ABP Ref: ABP-310461-21

Further Development of a Quarry

Application for substitute consent under Section 261A of the Planning and Development Act 2000 as amended.

Laurence Behan, Windmill Hill, Rathcoole, Co. Dublin

Drawing file: 03 - Substitute Consent Drawings / 310461 - 32 - Storage Drying Shed - 100 A0.pdf

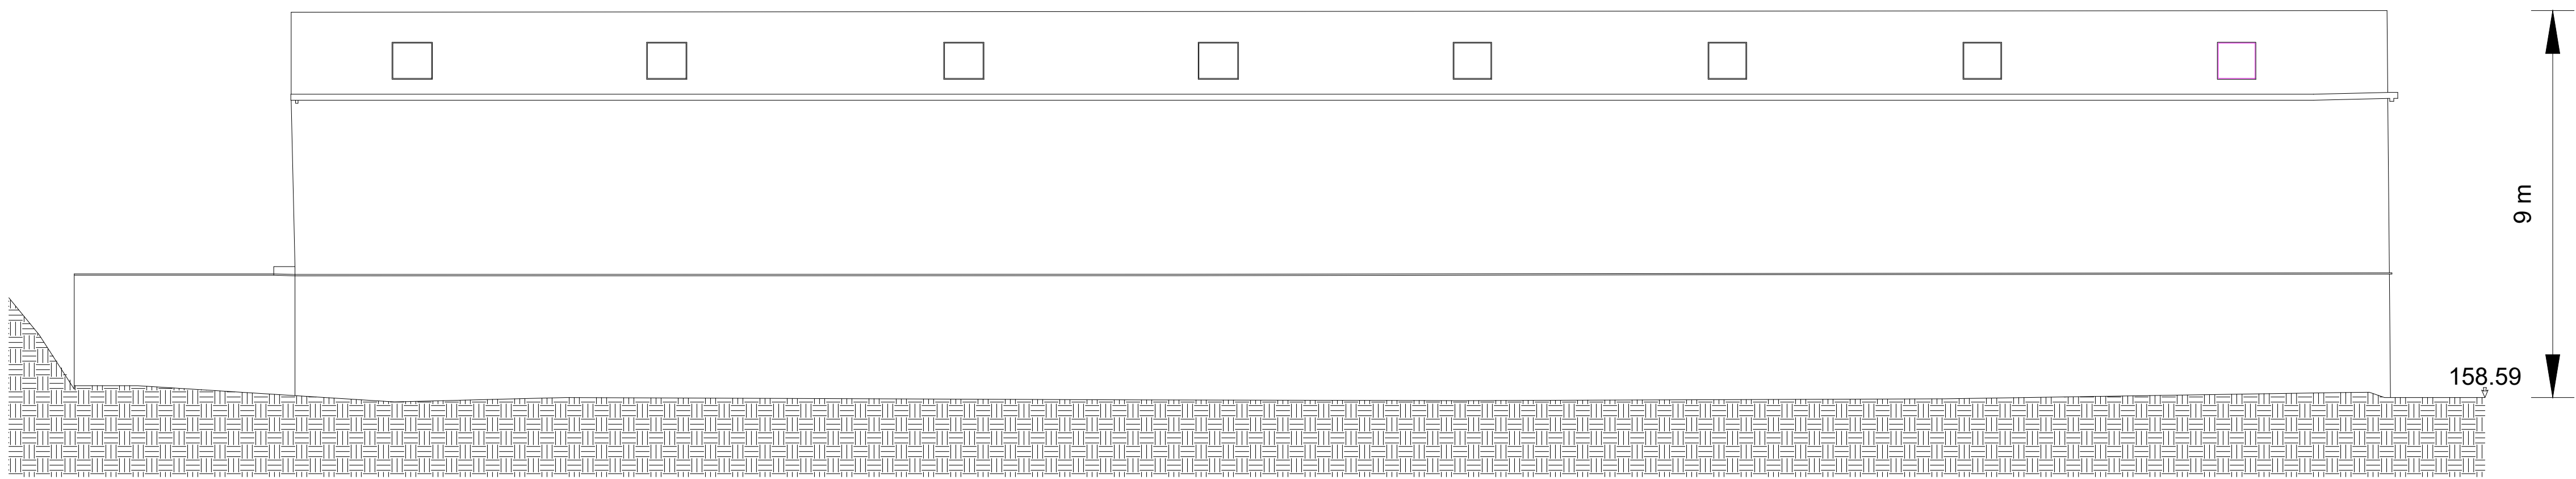
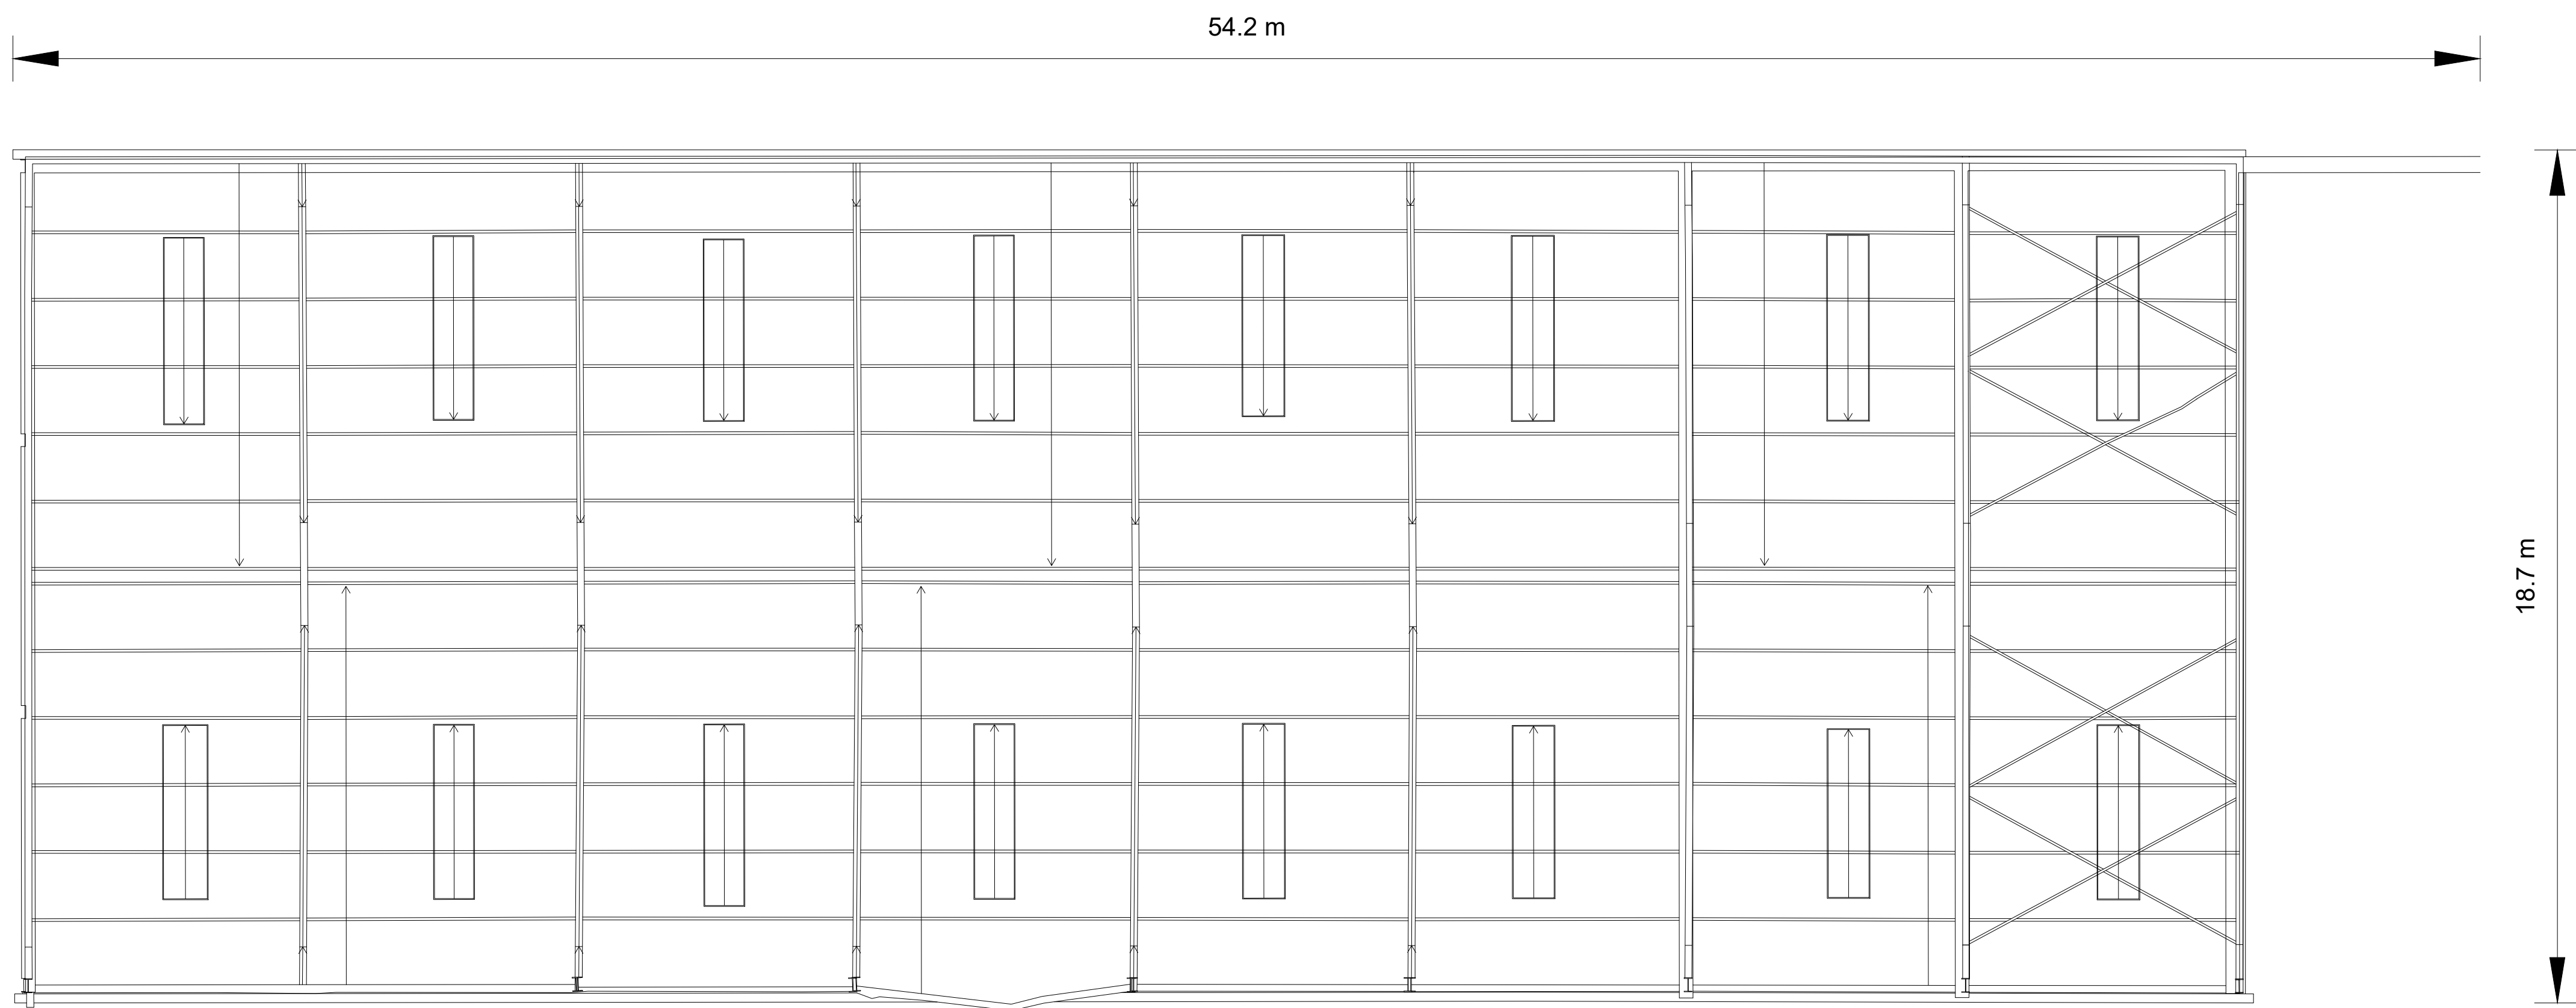
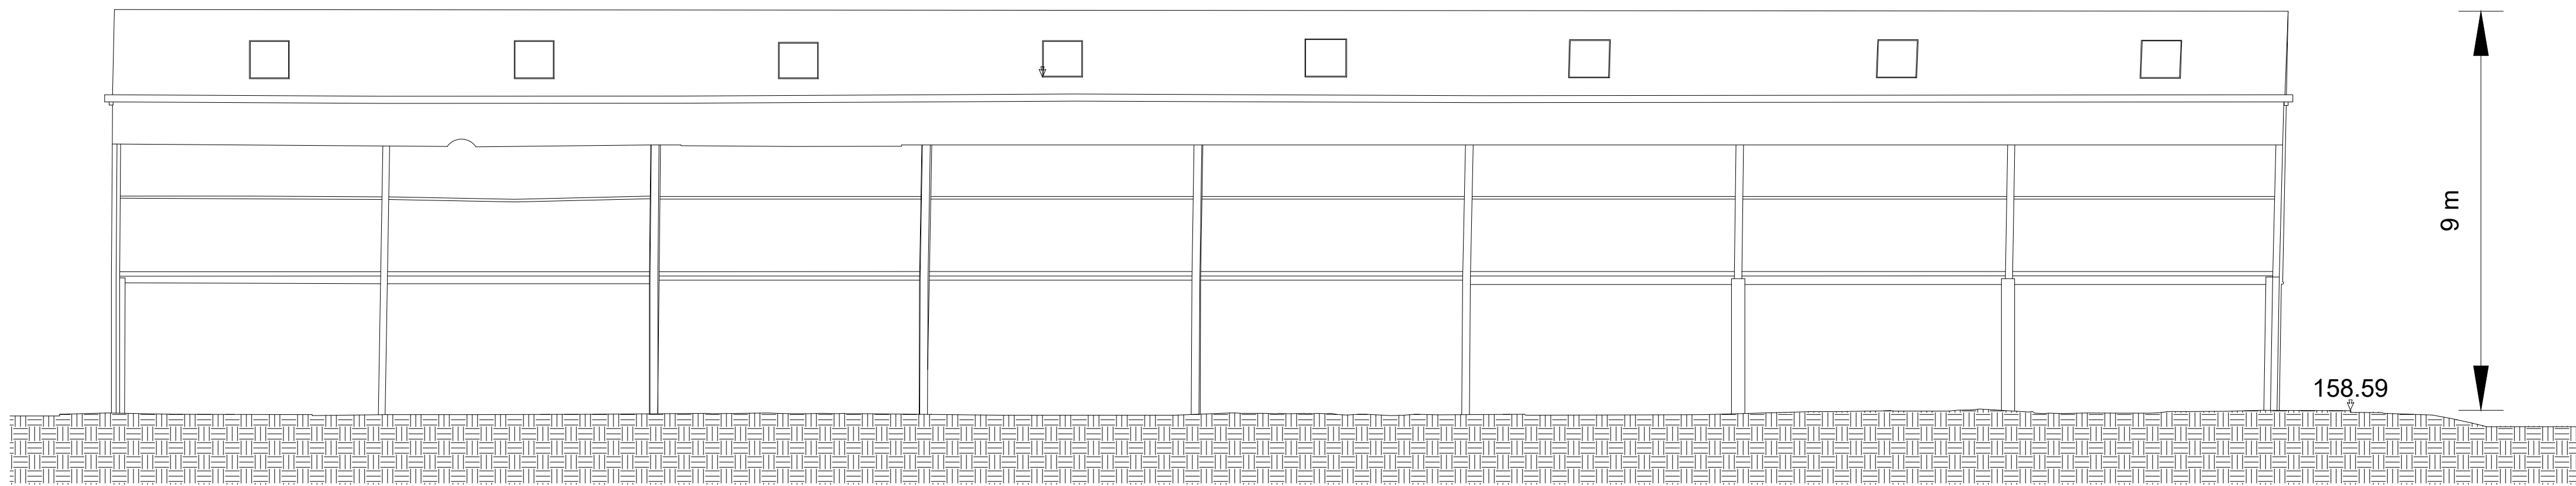
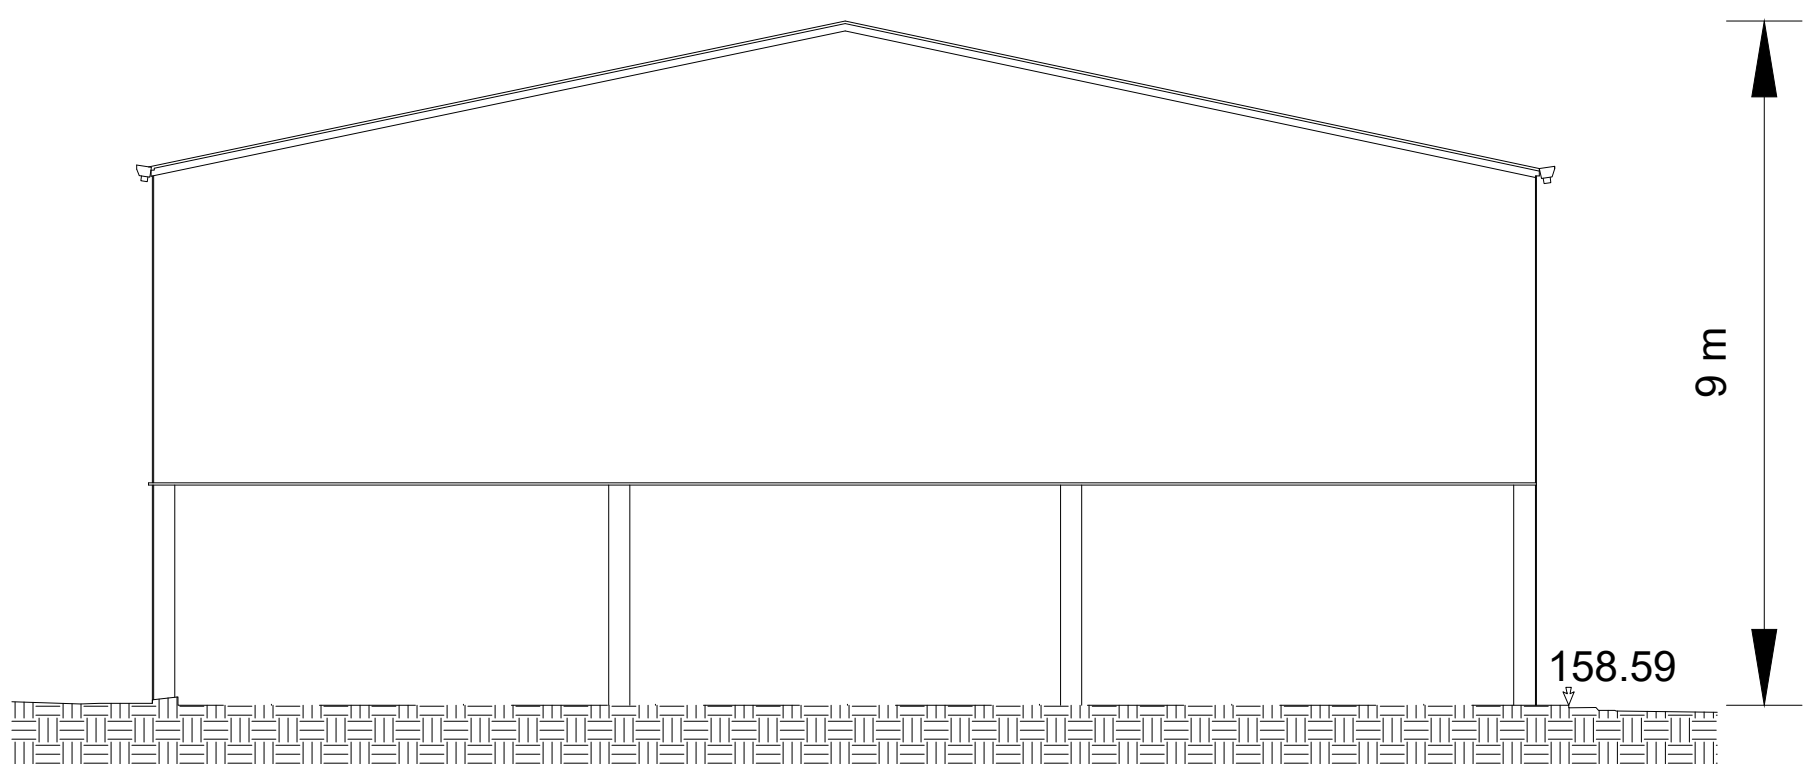
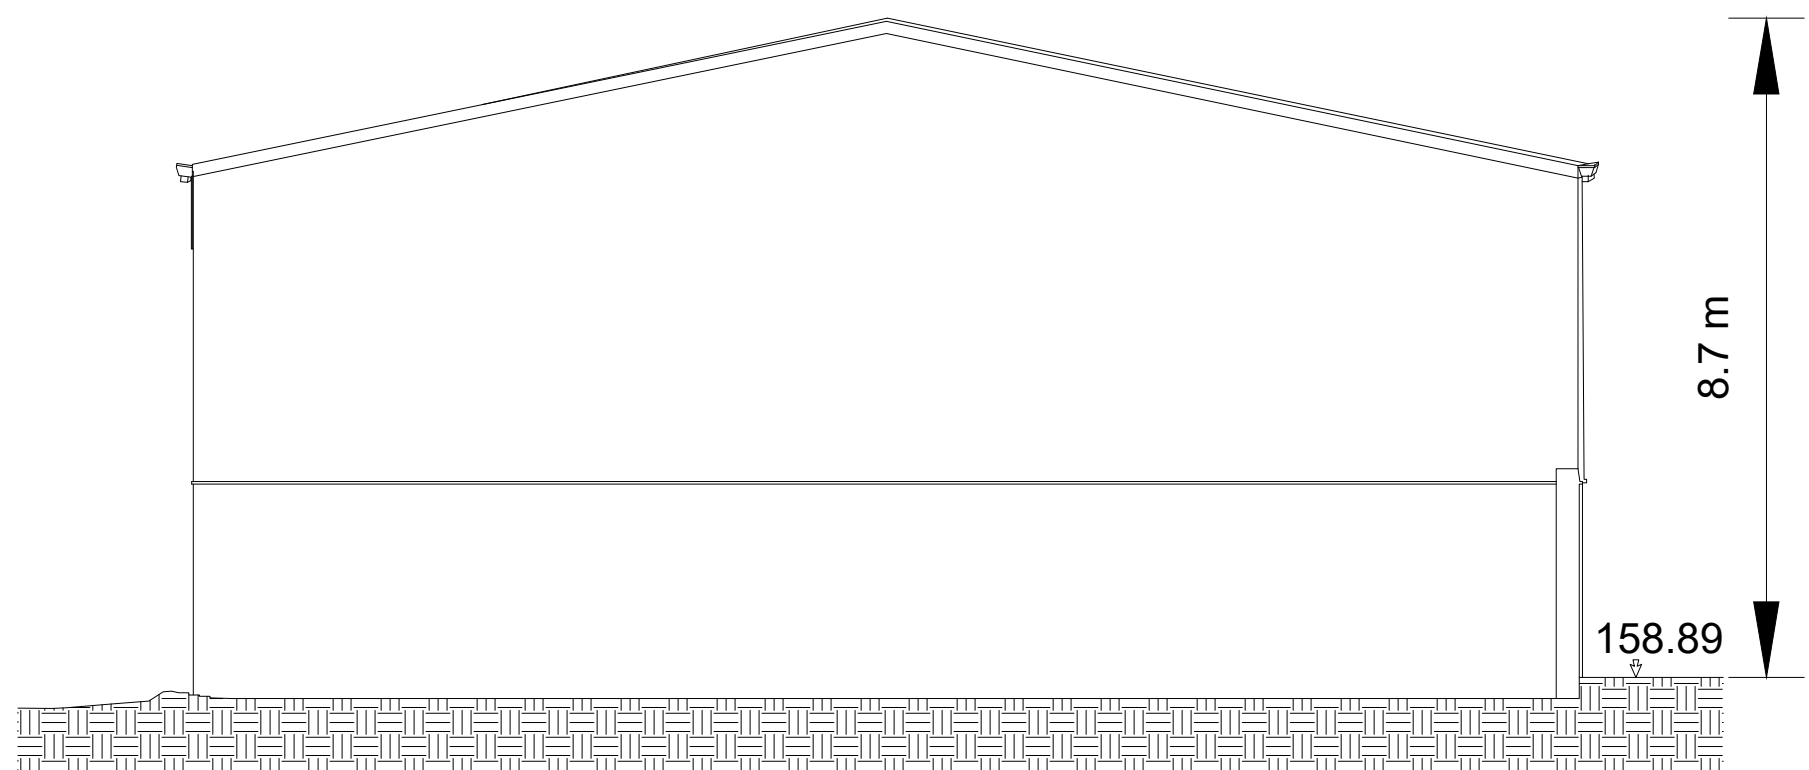
Item 9.2.3: The Planning Authority cannot trace planning permission for the following development:

- a. 2 x office buildings,***
- b. 4 x portacabins,***
- c. 4 x containers.***
- d. 2 x storage/maintenance sheds,***
- e. a storage/drying shed,***
- f. water recycling unit and silt press.***
- g. a concrete plant and washing, crushing, screening and bagging plants.***

The Planning Authority recommend that additional information should be requested to establish the status of these works/development and seek the applicant, to submit all

relevant planning permissions for the above development and/or a proposal for regularising the development, if necessary.

Please see our comments above on these 7 features, identified in our reference above to Section 4.3 with regard to these and other features of the site for which planning needs to be regularised. We believe the above text clearly identifies the planning status of the above and other features on site. The applicant accepts that several of above items (a) to (g) would appear unauthorised and that planning permission is required where re-location is involved but we would point out as we did above, that several of these features have been removed.
